**From:** Julie Redpath   
**Sent:** 19 April 2018 11:48  
**To:** Planning; Andrew Wood  
**Subject:** FW: AB/25/18/A & AB/26/18/L Swan - Arundel Further Revised Drawing  
**Importance:** High

**From:** Julie Redpath  
**Sent:** 13 April 2018 16:28  
**To:** 'planning@arun.gov.uk' <planning@arun.gov.uk>  
**Subject:** AB/25/18/A & AB/26/18/L Swan - Arundel Revised Drawing  
**Importance:** High

Sign C -
1 no. d/s accommodation panel fitted to the underside
of the retained existing pictorial sign and cartouche,
with new LED trough lights
Size: 900mm x 200mm
Scale: 1:10
**Decorators to paint existing wall bracket*

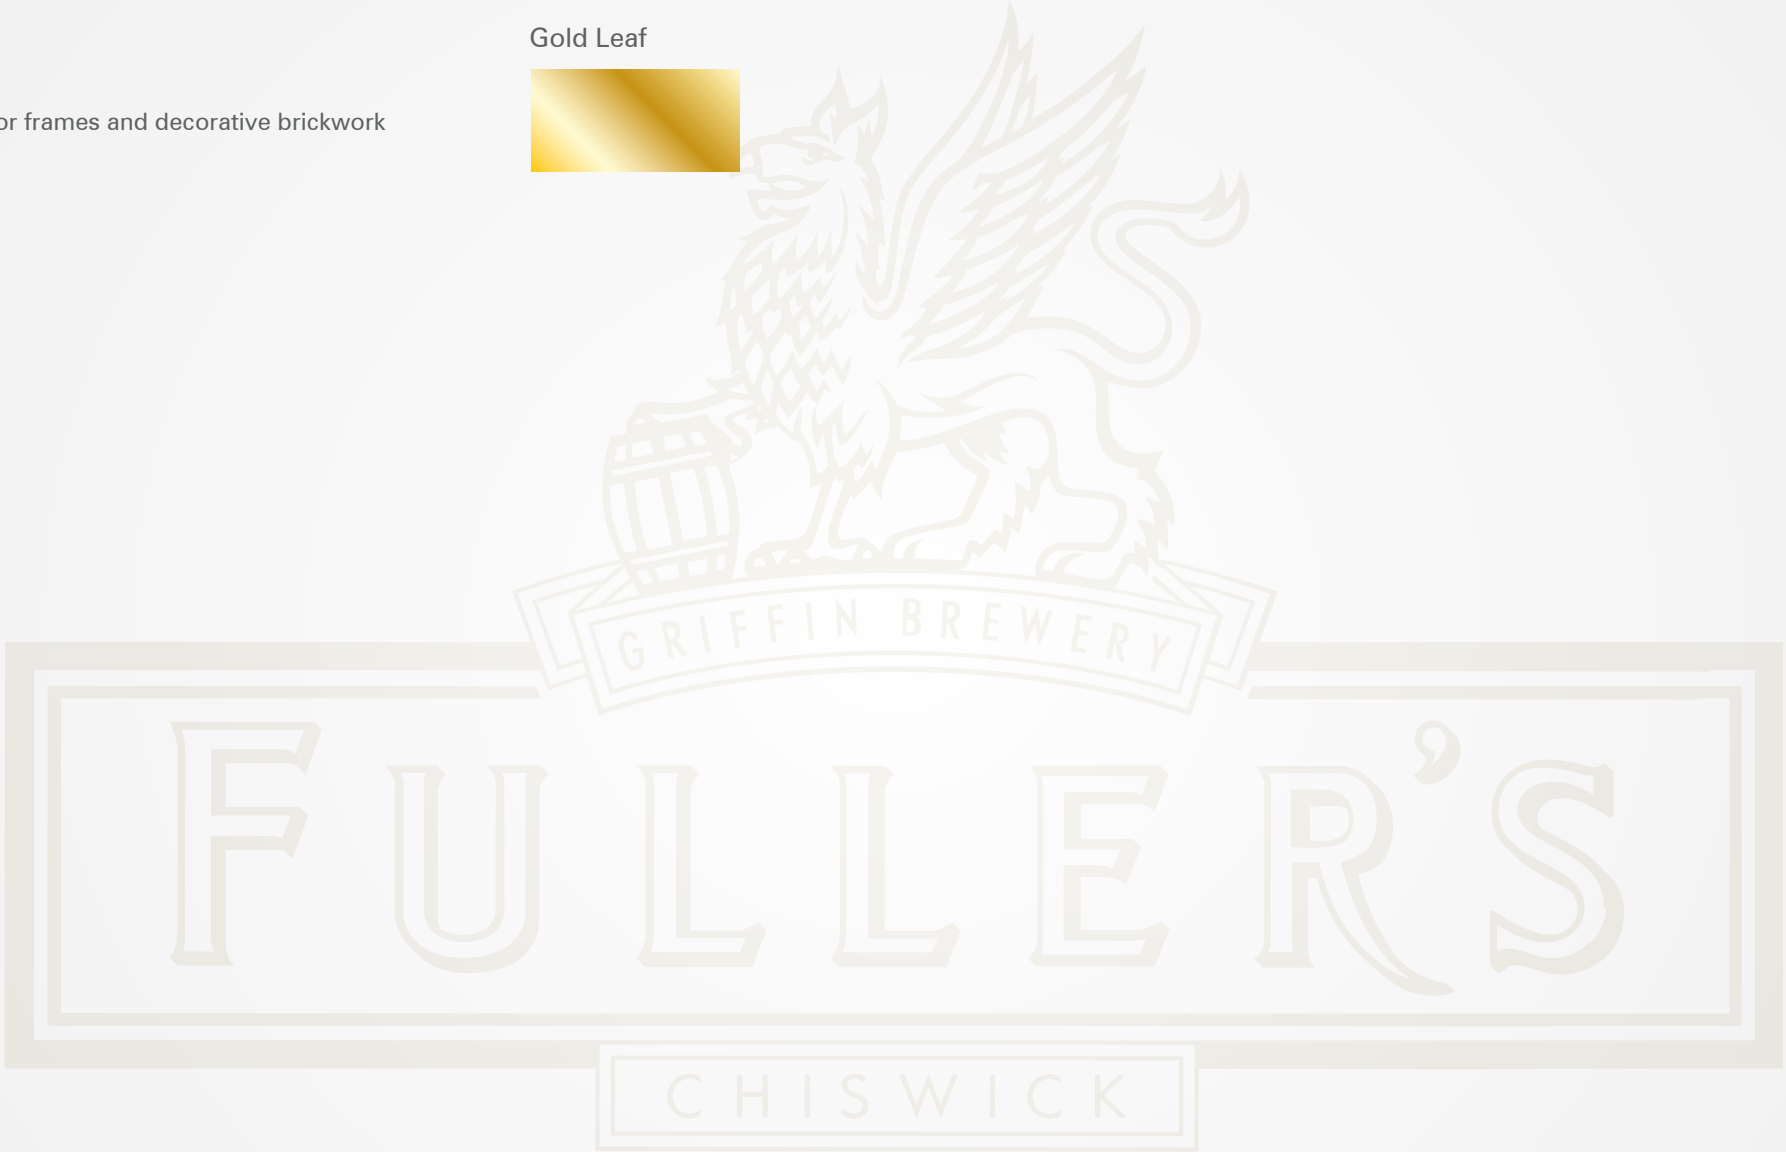
Apologies, we have been asked to amend the signage scheme further and have attached the re-revised drawing, the addition is an accommodation panel added to the bottom of the existing wall mounted pictorial sign the size is 900mm long x 200mm high and 50mm deep with approx. 50mm gap between the panels, the construction is the same as the existing pictorial and the height from the ground to the underside is 3770mm.

Our customer has advised that they are now to retain the existing pictorial panel and noticed that the floodlights to illuminate the building are shown in all the photos and elevation drawings but had not been specified on the front schedule this has been amended and does need to be included within the application please.
